From: Amanda Scholes on behalf of Planning.Responses
Sent: 09 April 2018 08:57
To: Planning Scanning
Subject: FW: Please find attached amendment on planning application Ref: R/267/17/PL

APPLICATION R/267/17/PL

Site Address: Rustington Hall Nursing Home Station Road Rustington BN16

Description of Works: 2 storey block of 6 No Flats comprising of 4 No. 2 bed & 2 No. 1 bed flats.

EXISTING SITE PLAN and Existing
Drainage
Rustington Hall
Station Road
Rustington
BN16 3AY

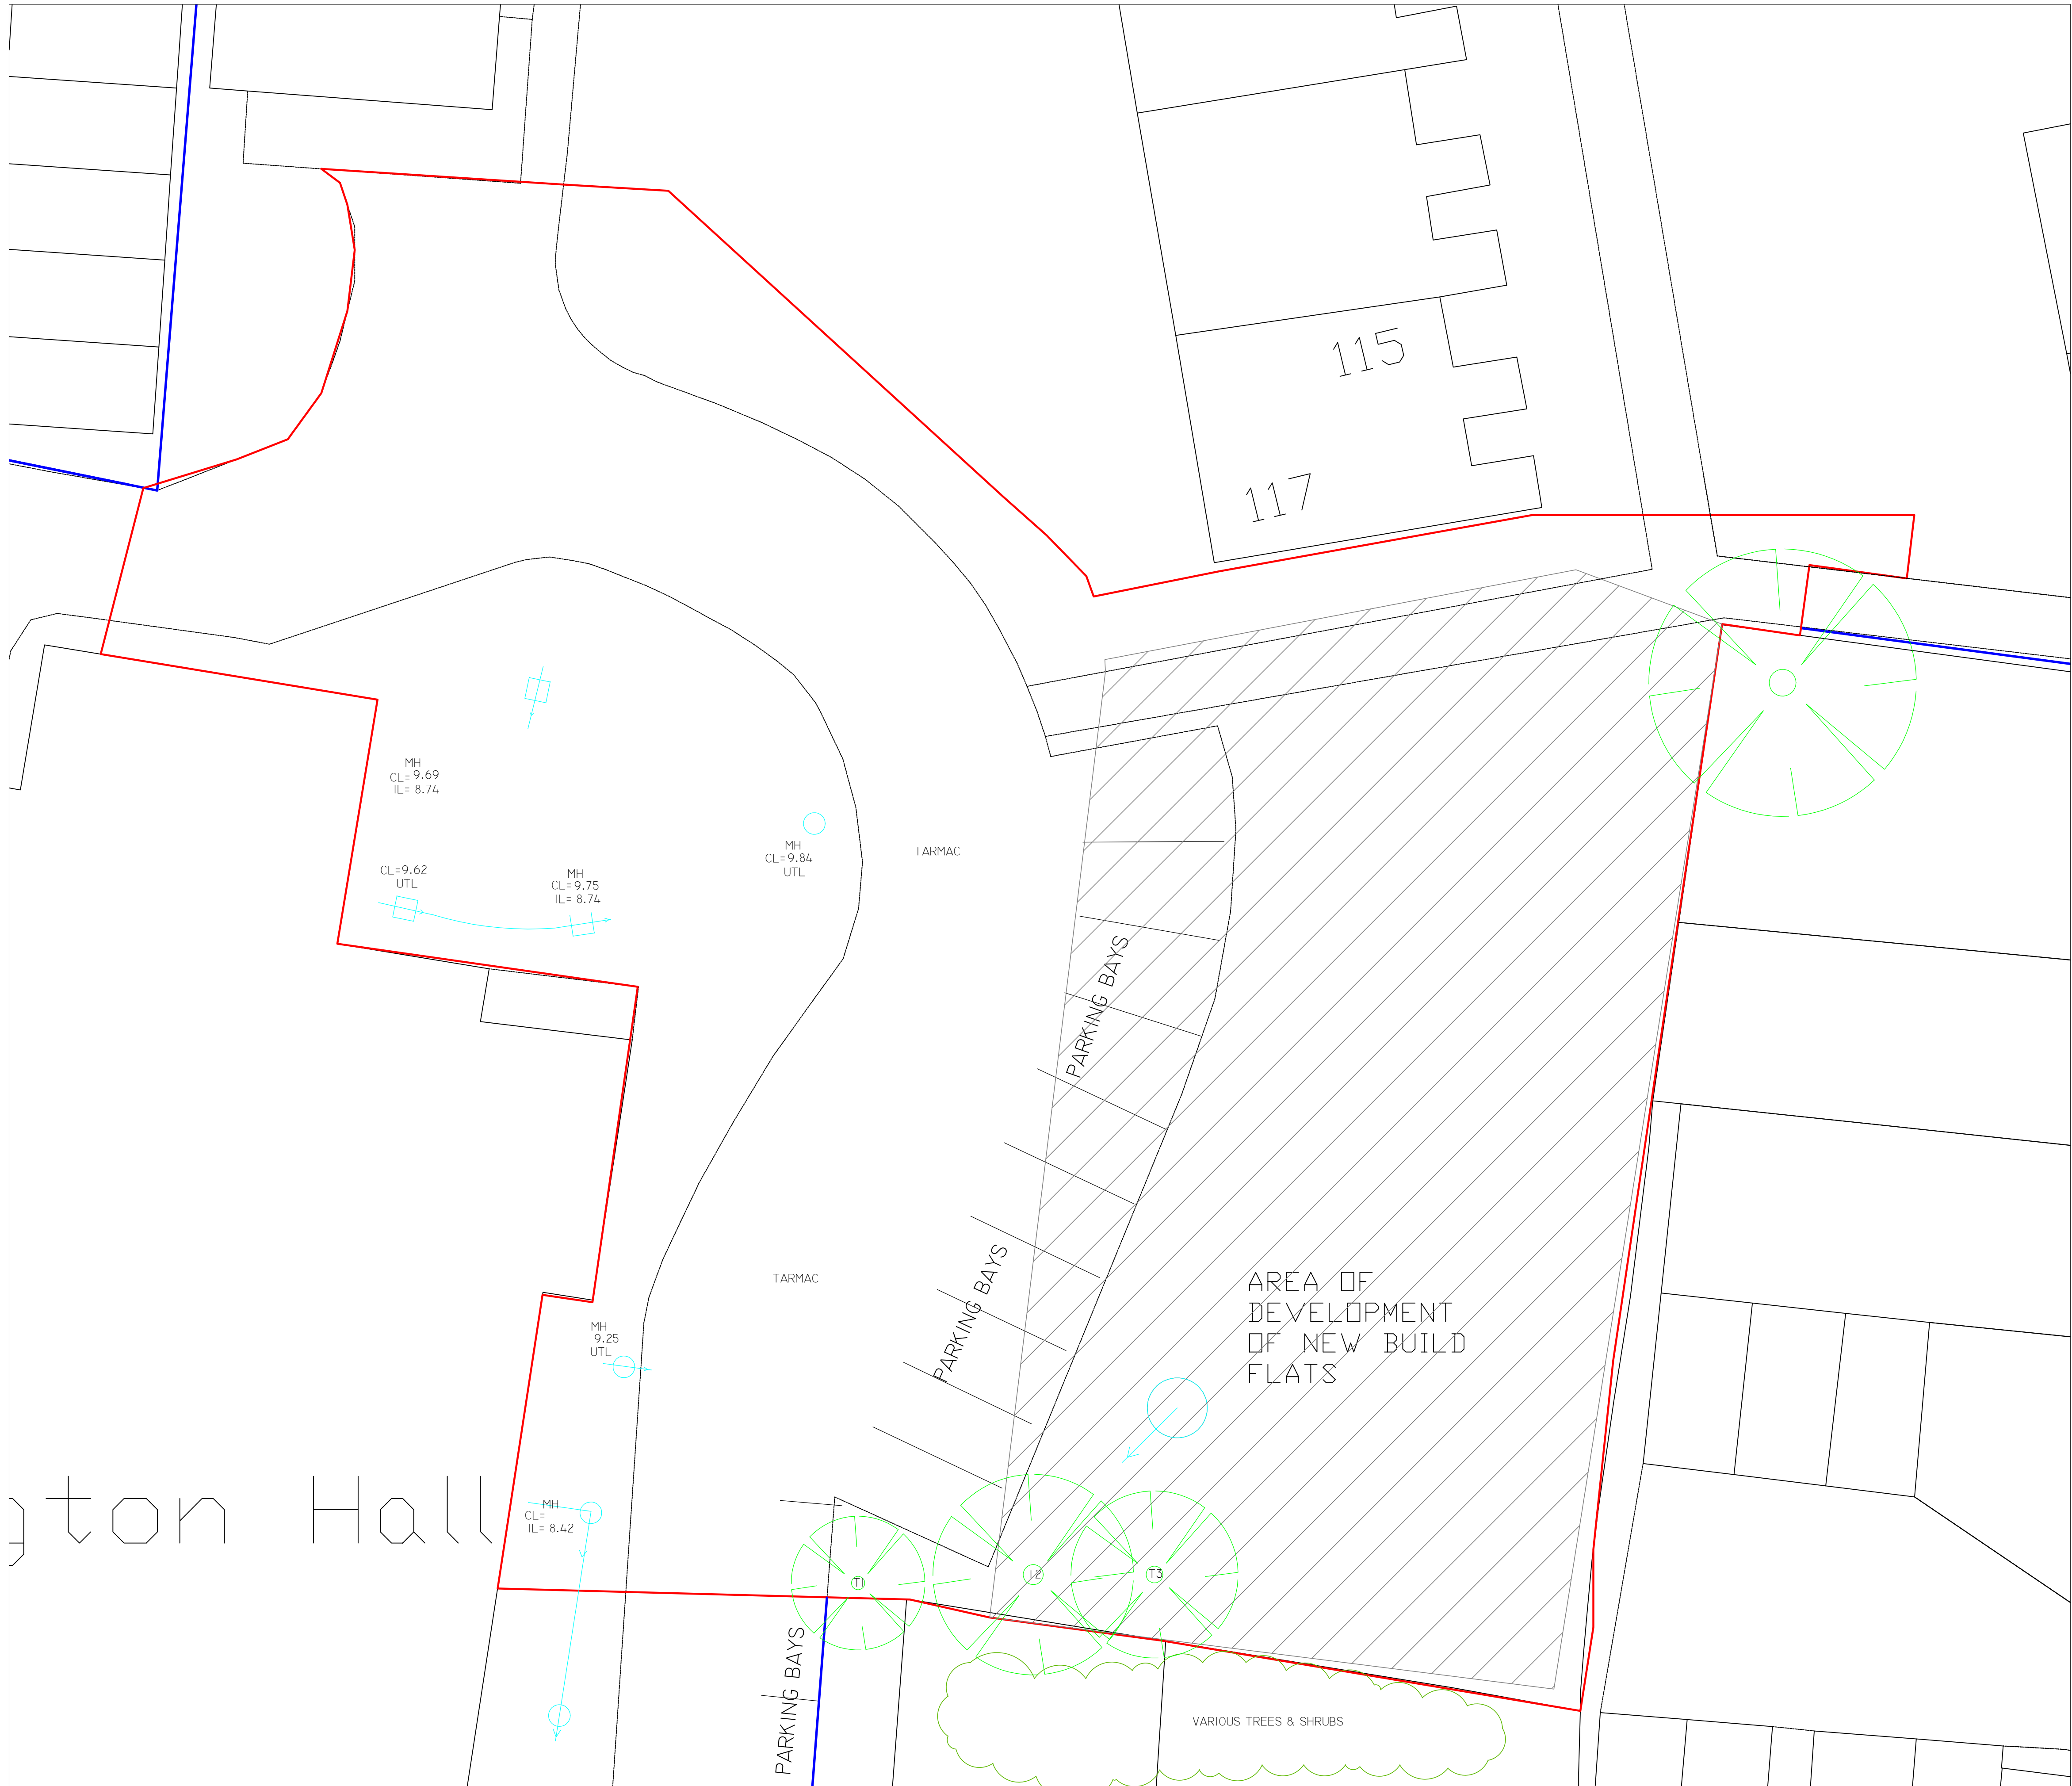
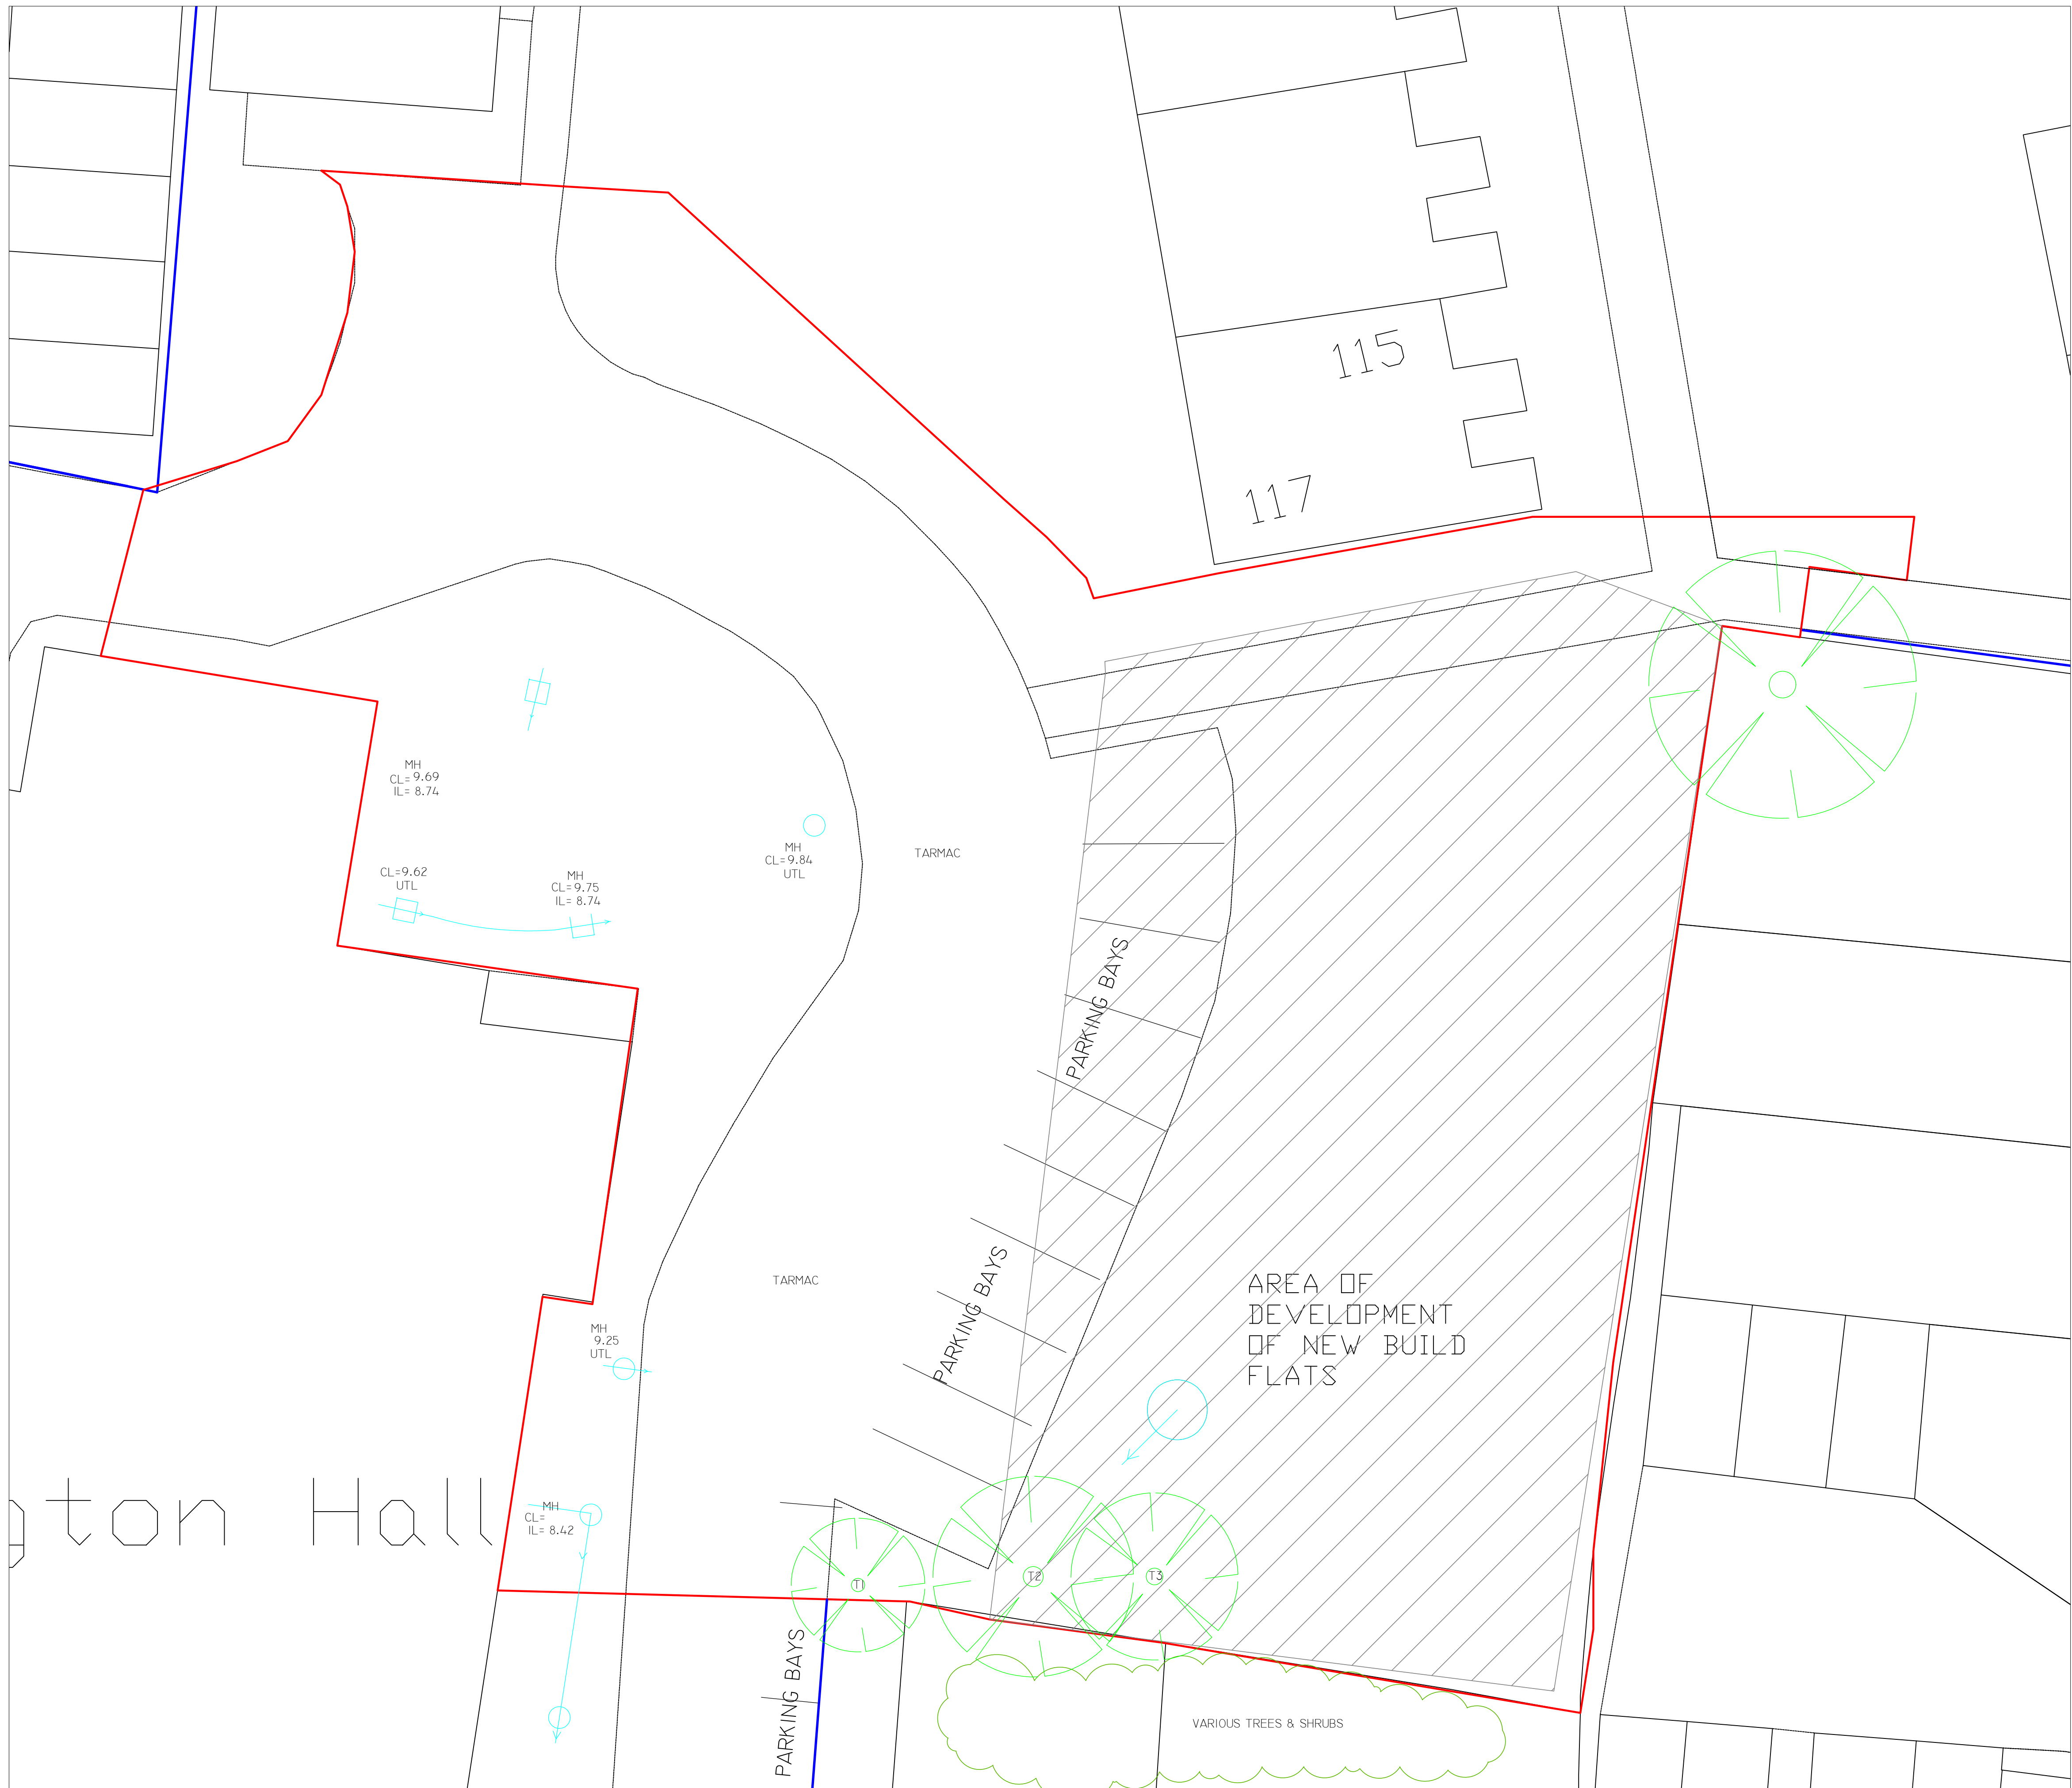
In principal the plans provided are okay. Further detail will be required to discharge this condition including:

- percolation test results;
- calculations;
- detailed plans, showing all diameters, gradients, and levels; and
- construction details of manholes, soakaways, silt traps.

Safety factors will need to be included in the design as ground water level monitoring was completed in March, after peak levels. The same will apply to percolation rates if percolation tests were also completed in March.

It should be noted that the Environment Agency may need to be consulted regarding the proposed relocation of the deep bore soakaway.
